Application by National Grid Electricity Transmission Limited (the applicant) for an order granting development consent for the Sea Link project

Written Representation on Proposed Changes to the Sea Link Development Consent Order

One of the five changes relates to the Kent element of the Project and therefore whilst the other four changes are noted, we will only comment on proposed Change 1: Change to access at the Hoverport, Kent.

Figure 2. Current and proposed changes to Order Limits in the former hoverport area

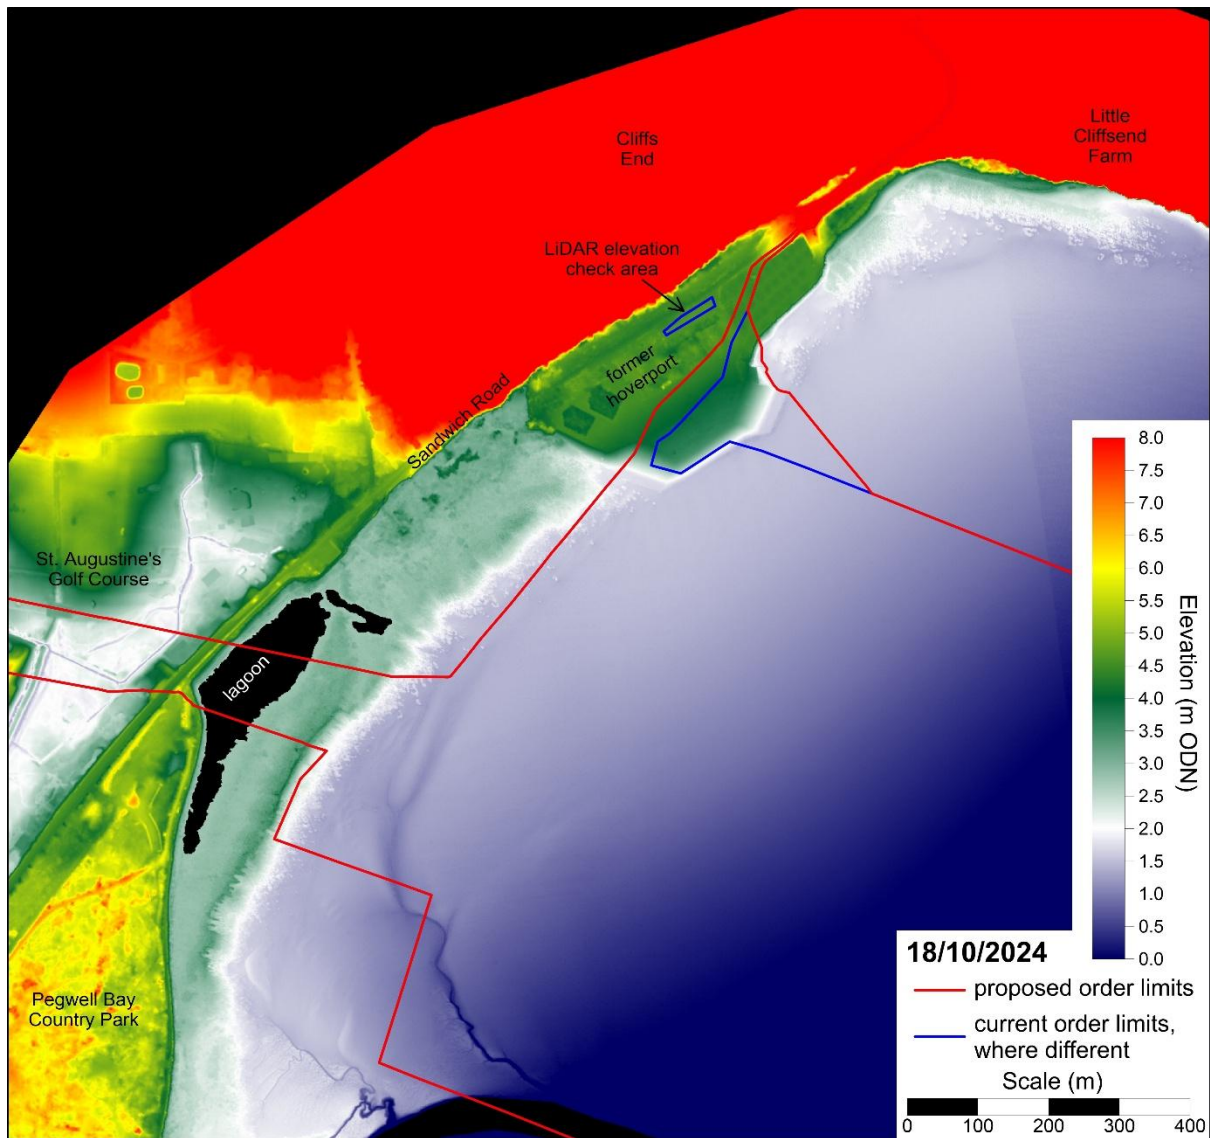
As highlighted above, the access route has not yet been determined and the Council is concerned that the ramifications of using (the identified) vehicles to travel over the site (and in the number proposed) are not fully understood. Survey work has not been undertaken for the project regarding the condition of the surface and having regard to the historic use of the site (contamination from previous maintenance areas on the site), it is not clear what the potential impacts on controlled waters may be from use of the land. As such, mitigation (if required), and the suitability of any such mitigation cannot be determined and assessed, at this stage.

Should the survey work undertaken at the hoverport indicate that all routes would result in the diminishment of significant botanicals, the Council queries whether the access route would be determined on a hierarchical basis and if so what the criteria would be. The Council seeks confirmation that the findings of survey work would be shared and wider consultation with the relevant bodies, beyond the qualified ecologist present on site, undertaken if necessary, to determine the most appropriate access route to minimise ecological harm.
